**SECTION 4.55(1A) MODIFICATION APPLICATION – SSD 9670 MOD 3  
WESTERN SYDNEY UNIVERSITY INNOVATION HUB – 2-6 HASSALL STREET, PARRAMATTA**

This application has been prepared by Ethos Urban on behalf of Western Sydney University (applicant), pursuant to section 4.55(1A) of the Environmental Planning and Assessment Act 1979 (EP&A Act) to modify Development Consent SSD 9670 relating to the Western Sydney University Innovation Hub at 2-6 Hassall Street, Parramatta (the site).

Title
**STORMWATER MANAGEMENT PLAN
(ALTERNATIVE CONNECTION POINT)**

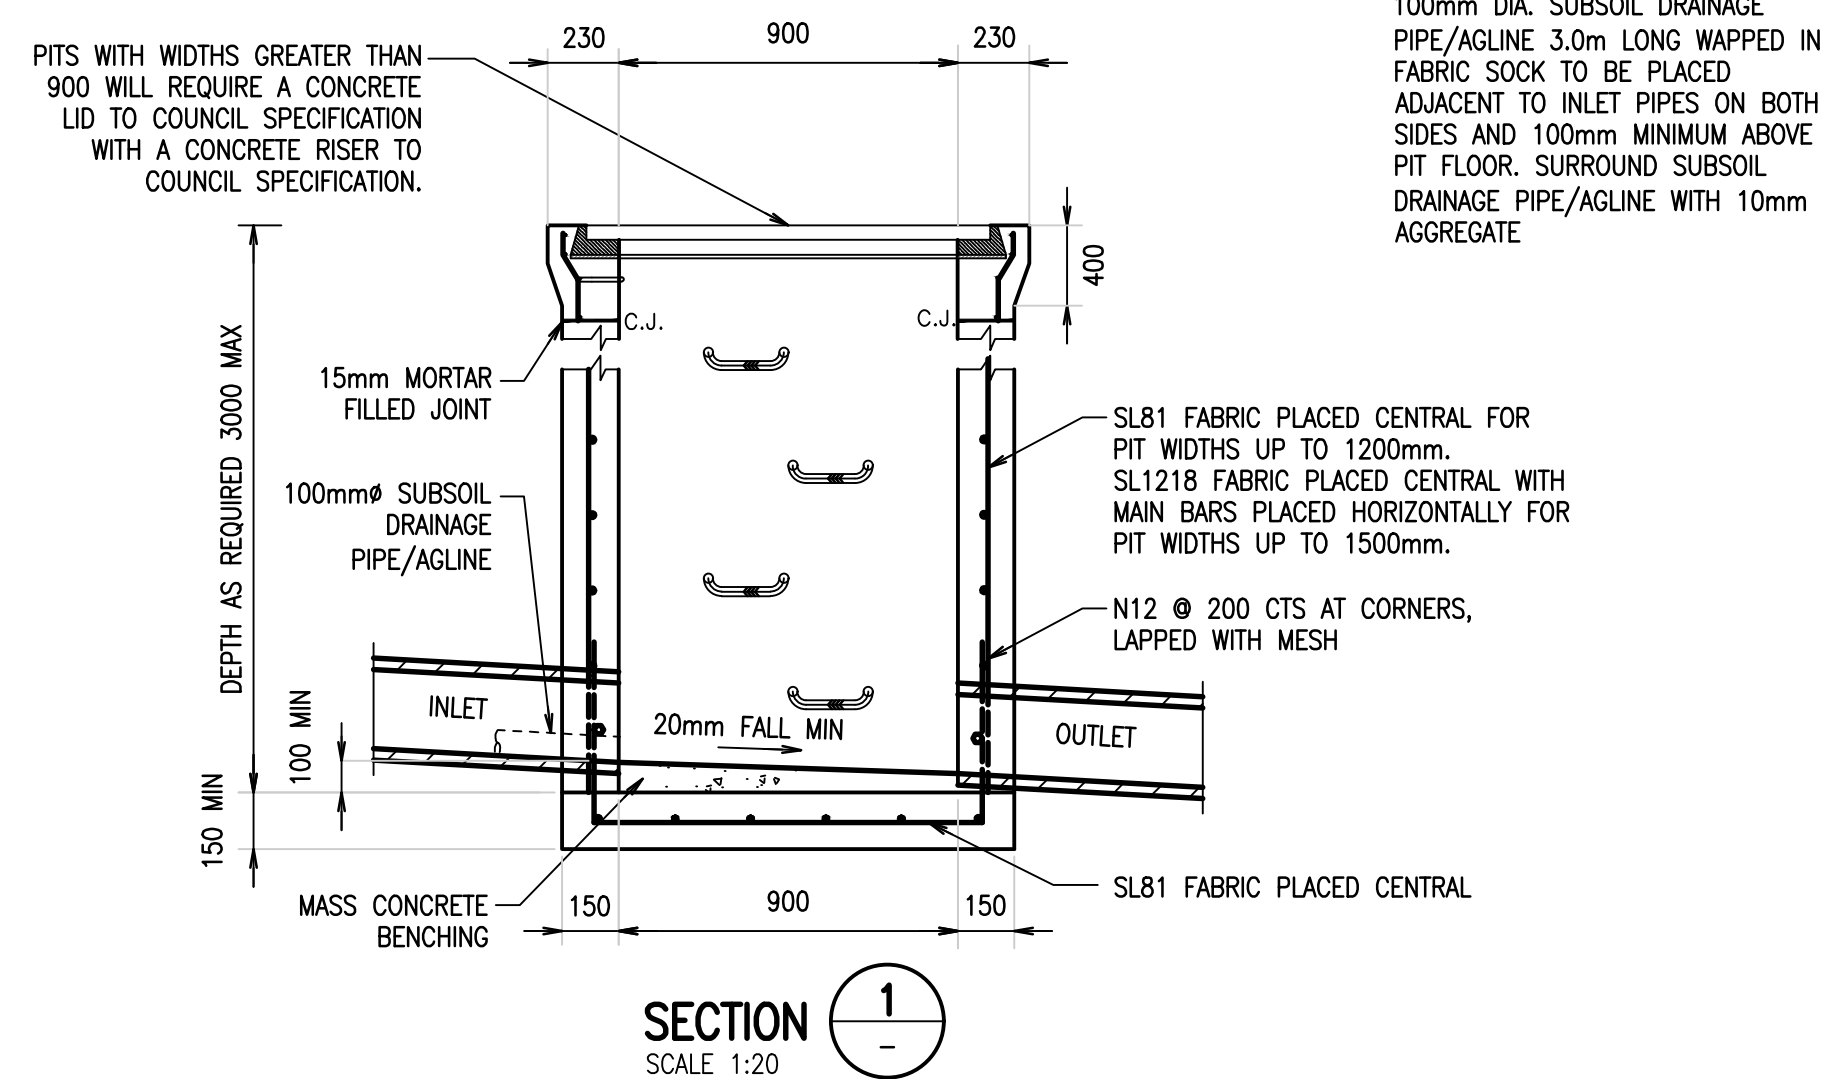
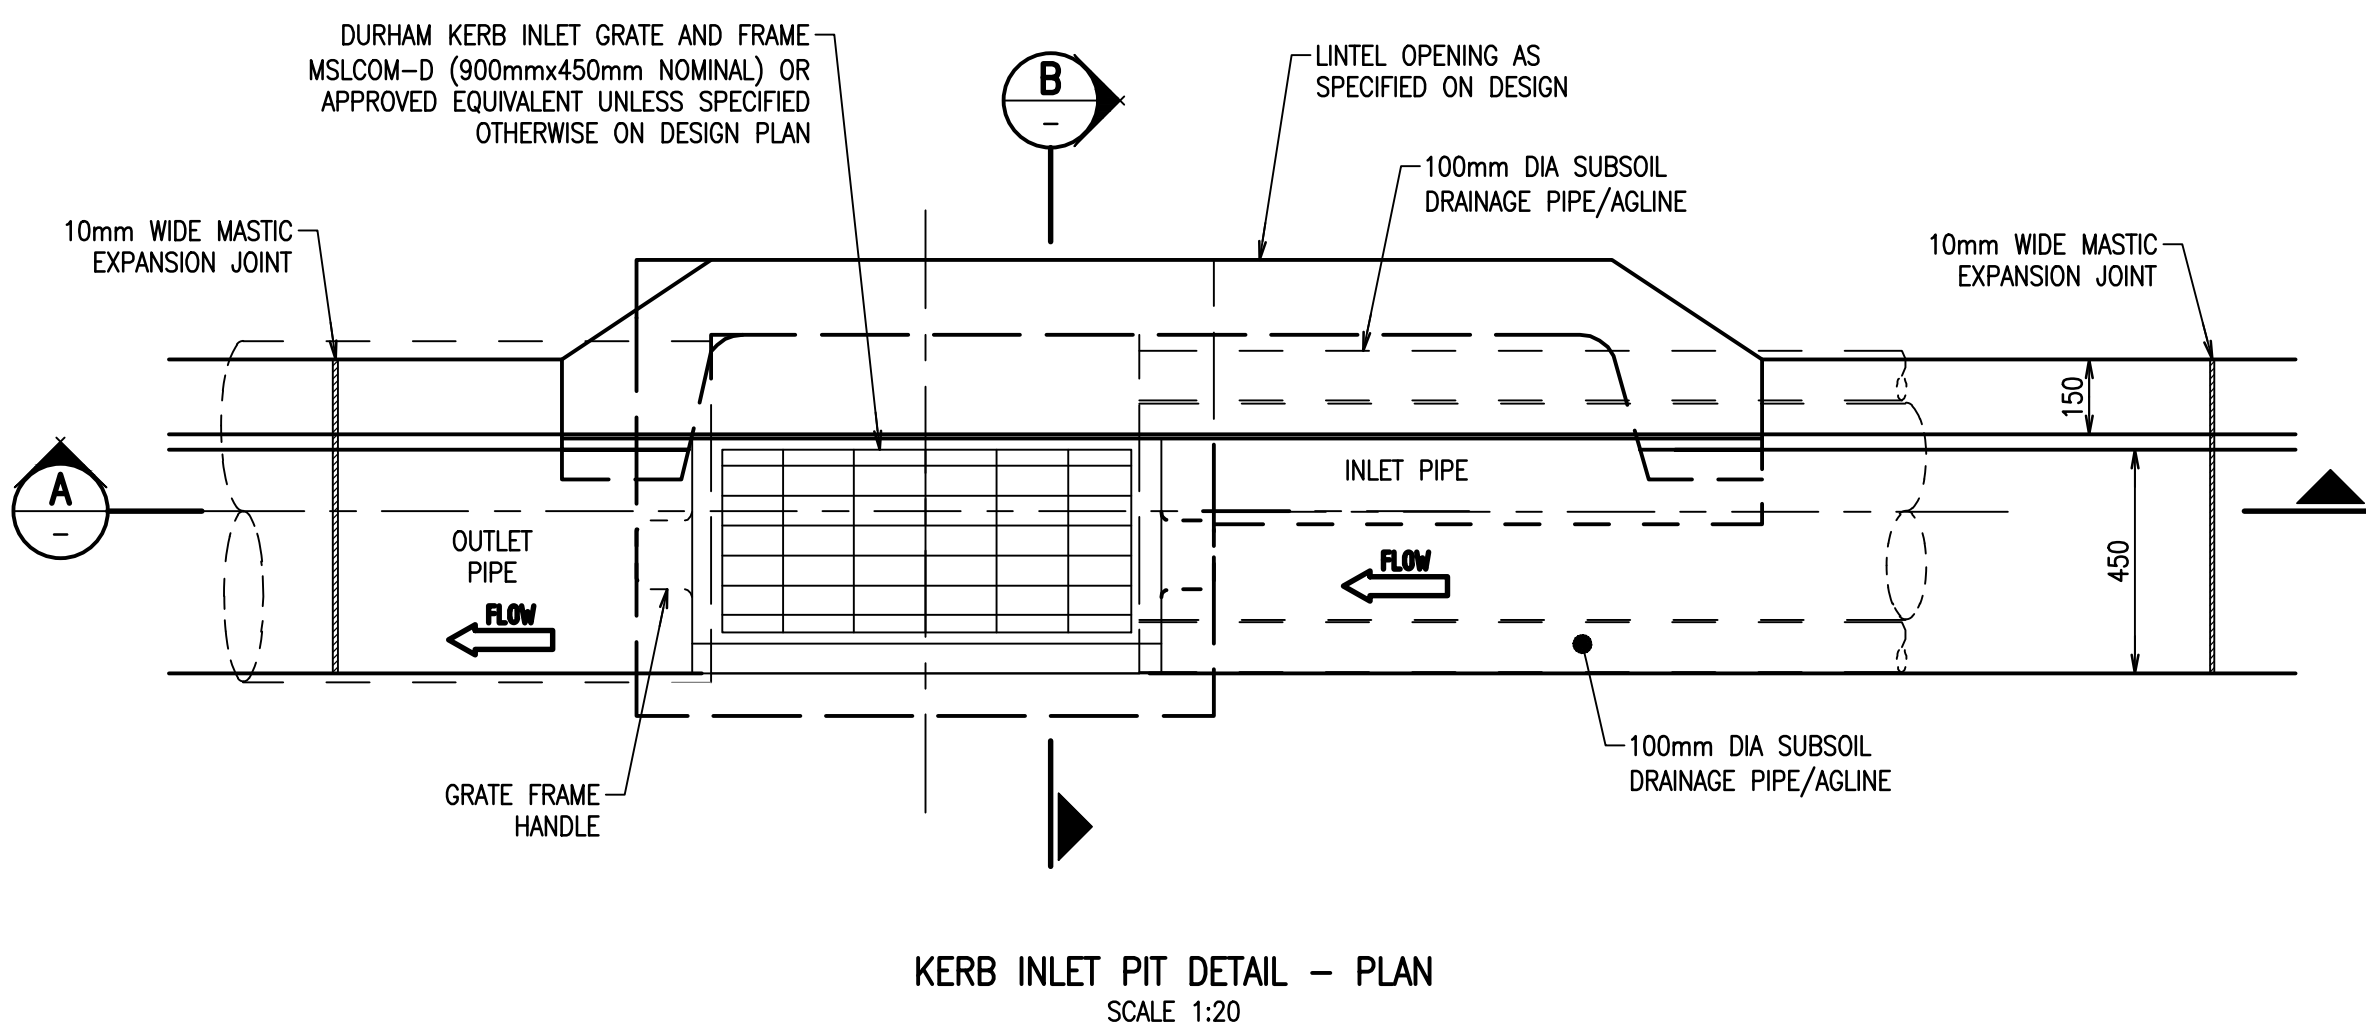
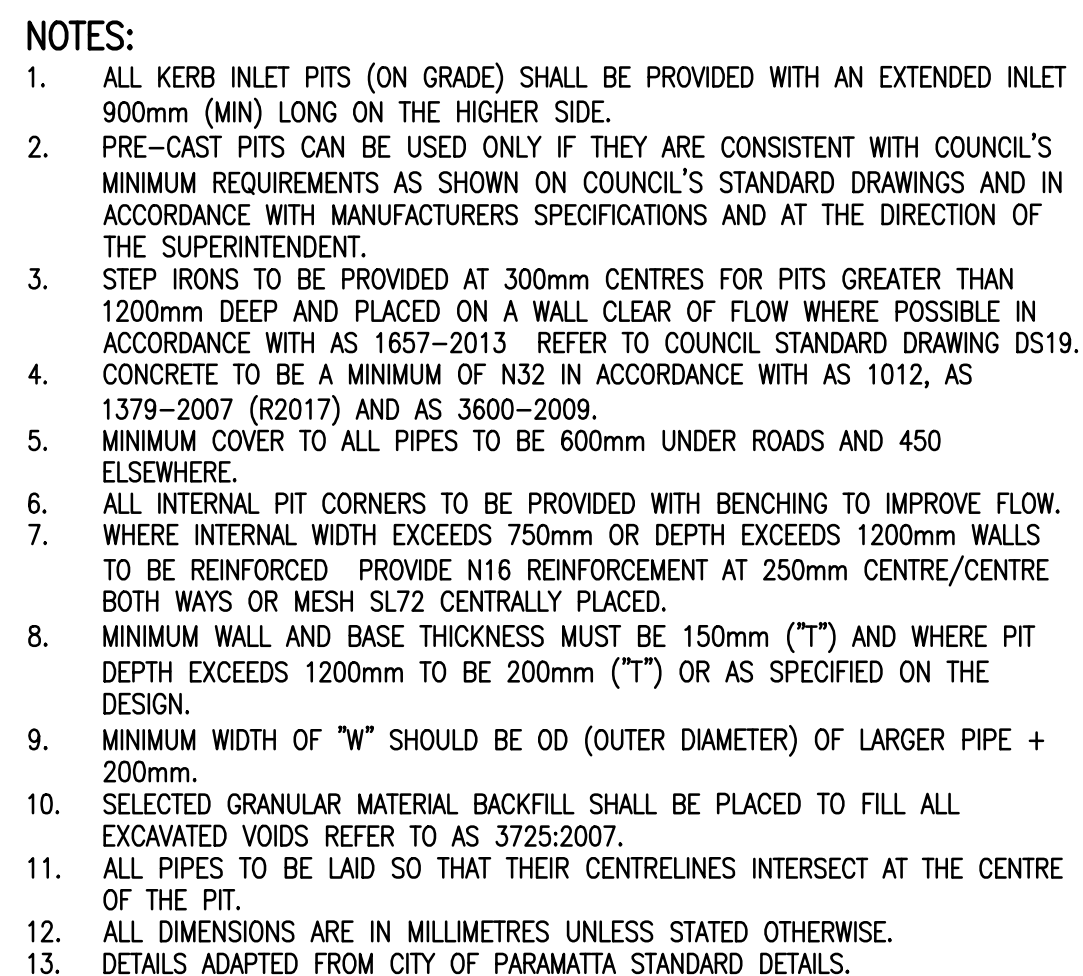
Detailed design development has revealed that the most efficient stormwater infrastructure design is not consistent with Condition B23 of the consent, which requires the pipeline to be connection to Hassall Street in an easterly direction. The project team has designed a westerly alternative which mitigates construction impacts and is provided at **Attachment B**. This alternative design which has been submitted to the City of Parramatta for review on 15 June 2020 and has received in principle support from Council's Senior Catchment and Development Engineer (with relevant correspondence provided at **Attachment C**).

The proposed alternative stormwater drainage design to Hassall Street in a westerly direction is illustrated within the Civil Infrastructure Drawings prepared by Robert Bird Group at **Appendix B**. The proposed stormwater design has been designed by a suitably qualified person, in accordance Council's standards, Australian Standards, Australian Rainfall and Runoff (Engineers Australia, 2016), and Managing Urban Stormwater: Council Handbook (EPA, 1997) Guidelines.

The proposed western stormwater option by Robert Bird Group, as illustrated within **Appendix B**, does not include kerb inlets and does not directly follow the kerbline for the whole length. Accordingly, the proposed amended condition wording reflects this difference and introduces flexibility within the consent for Council to endorse an alternative arrangement to their satisfaction.

- It reduces the amount of crossover points with existing underground services when compared to the eastern option which has a higher chance for disruption in the general vicinity during works;
- It has greater flexibility with pipe depth due to the availability of a deeper connecting point;
- It will result in less disruption to traffic flow due to the reduced length of trenching and potential services relocations; and
- It will result in a shorter construction period and will assist in achieving completion of the project sooner.

- (a) be designed by a suitably qualified and experienced person(s);
- (b) include a stormwater drainage pipeline ~~with kerb inlet pits along the kerbline of Hassall Street~~ from the site ~~eastwards then crossing Hassall Street to the~~ **to an appropriate** point of connection ~~near 13-15 Hassall Street,~~ with minimum 375mm diameter concrete spigot and socket pipe in accordance with Council's standards with an underground connection from the site to the kerb inlet;
- (c) be designed in accordance with On-site Detention and Water Sensitive Urban Design requirements in Parramatta Development Control Plan 2011;
- (d) be in accordance with applicable Australian Standards;
- (e) ensure that the system capacity has been designed in accordance with Australian Rainfall and Runoff (Engineers Australia, 2016) and Managing Urban Stormwater: Council Handbook (EPA, 1997) guidelines
